CITY OF ALBUQUERQUE

**Re: Anthea – 4th at Granite
Grading and Drainage Plan
Engineer's Stamp Date 9-3-14 (J14D171)**

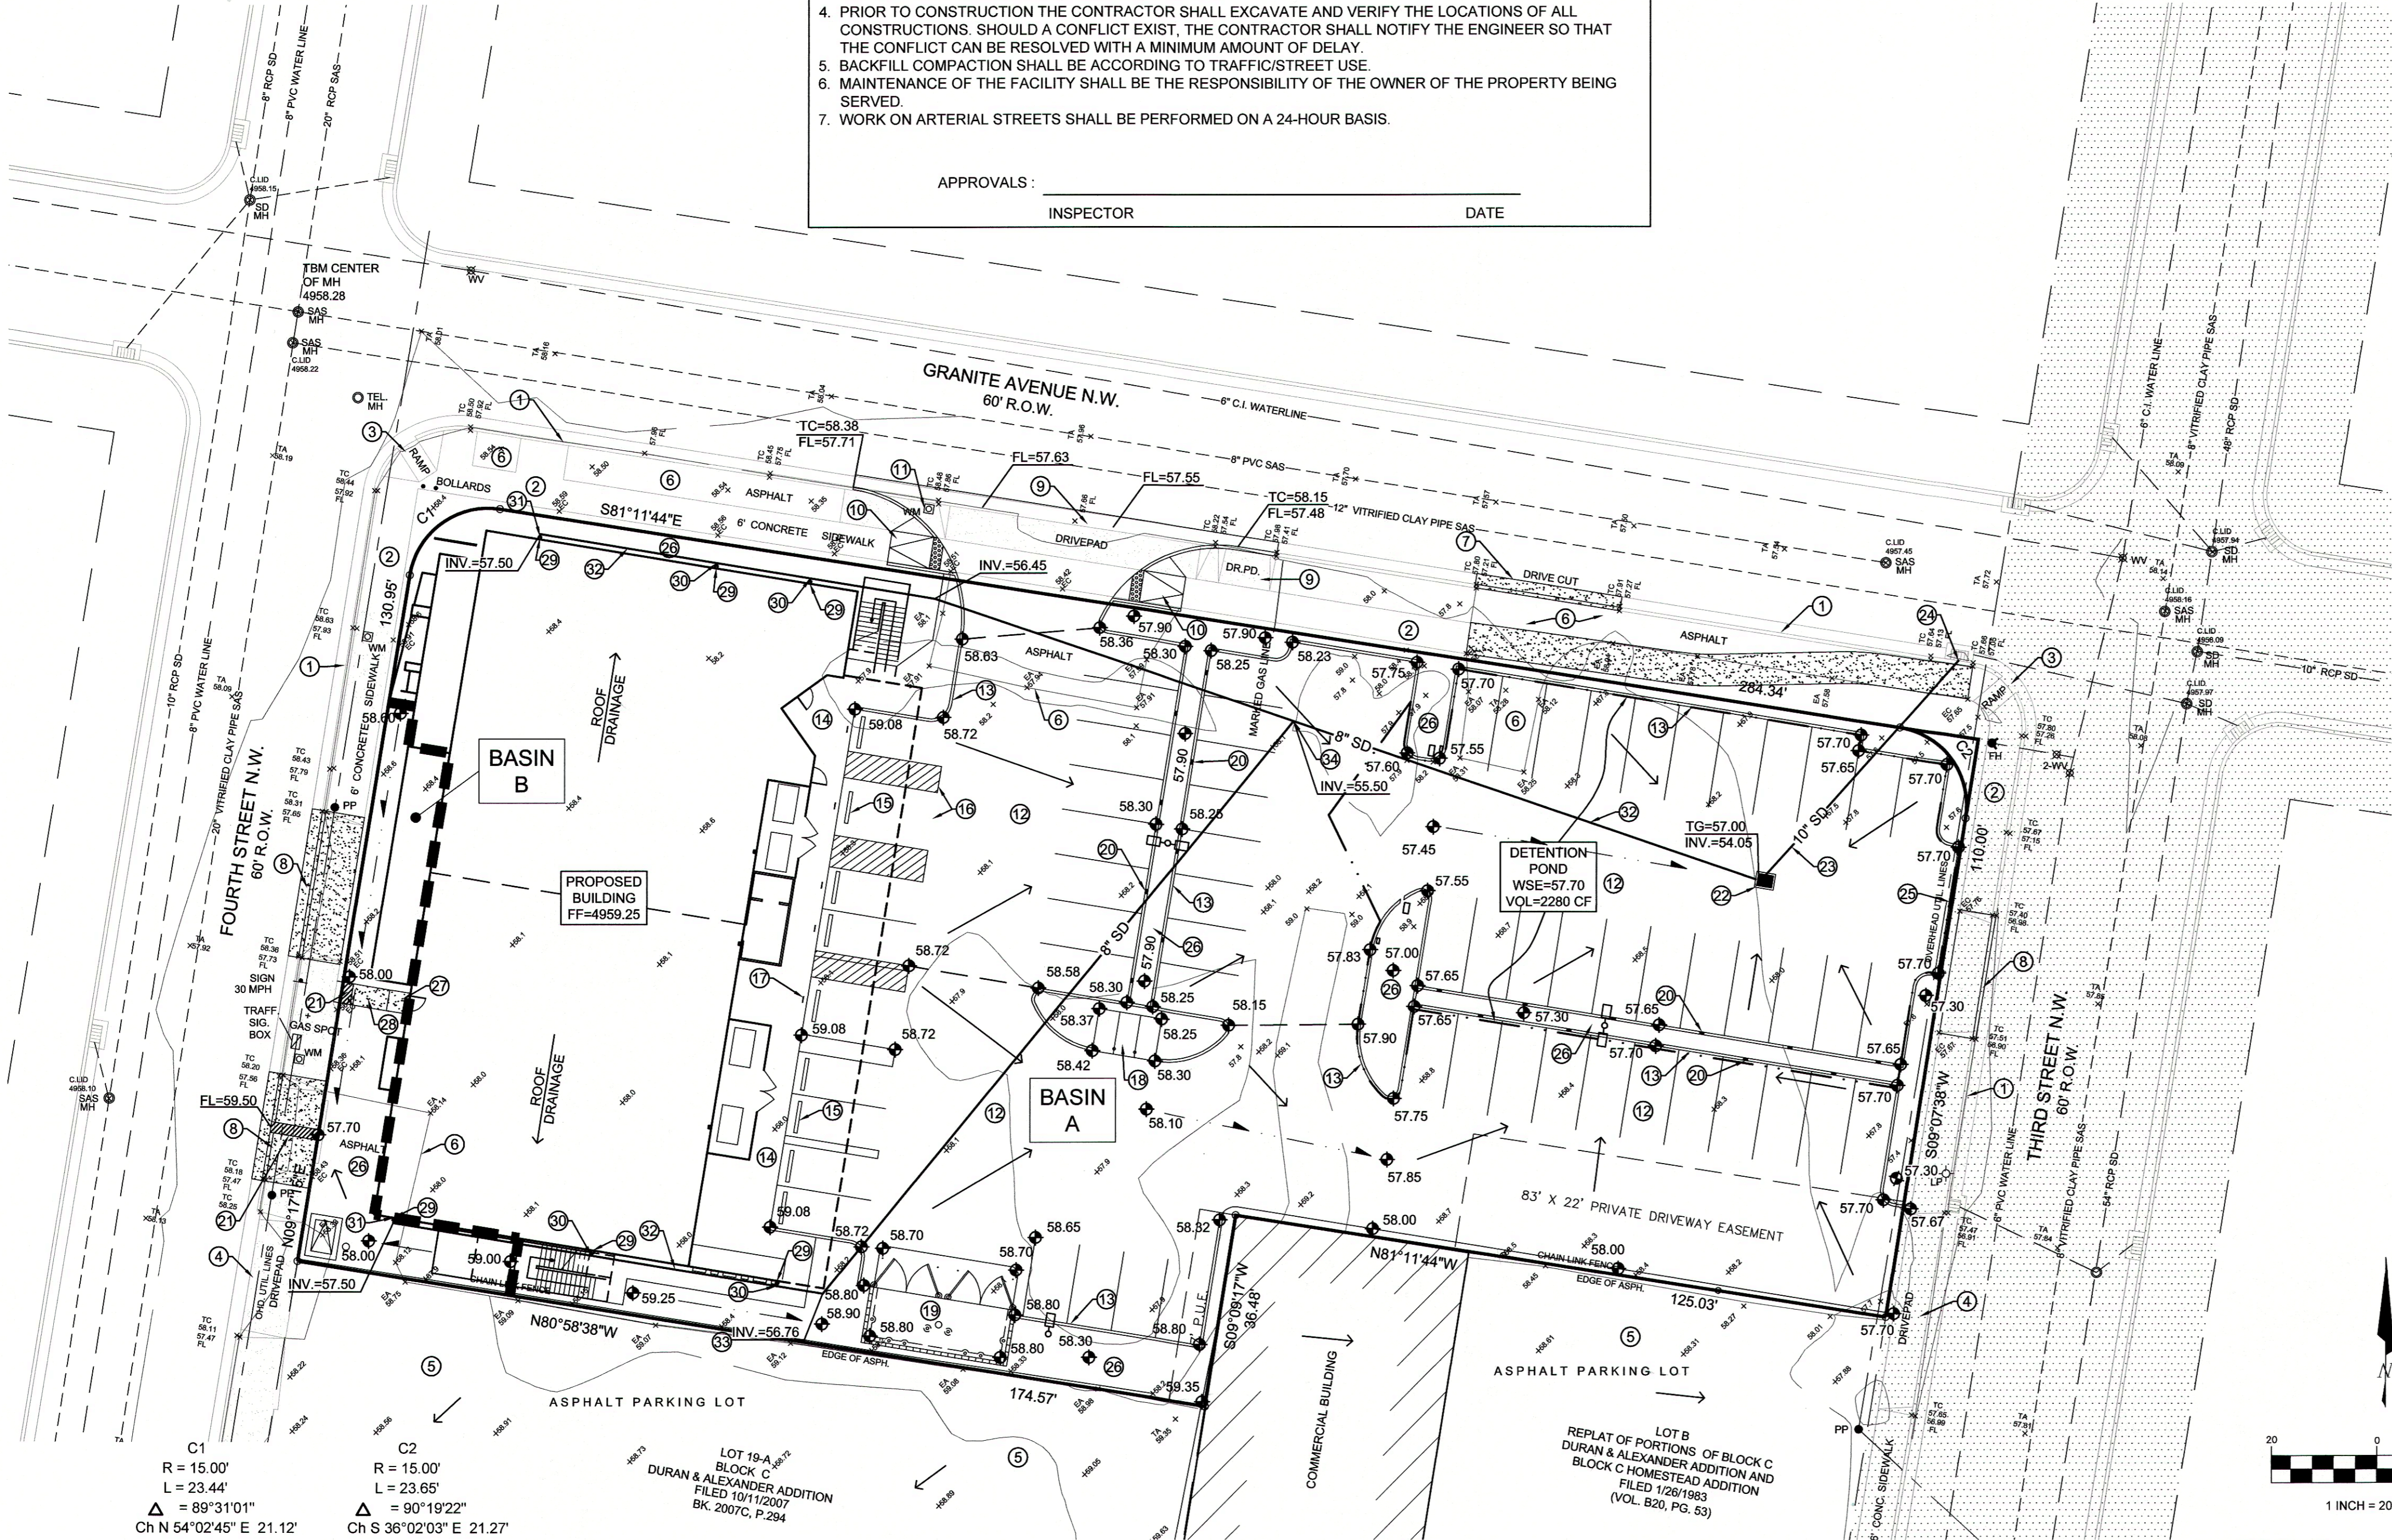
1. The First Flush calculations have a sum for the landscape areas that include all landscape area on site. However, drainage is not being directed into many of those areas. Revise the calculations to only include landscape areas where ponding is occurring. The inlet in the parking lot can be lowered and used for the First Flush also.
2. For the 8 inch storm drain on the northwest side of the building at 58.29, there is only 0.29 inches of cover. Provide more cover. Show an invert for the 8 inch storm drain connection on the south side of the building.
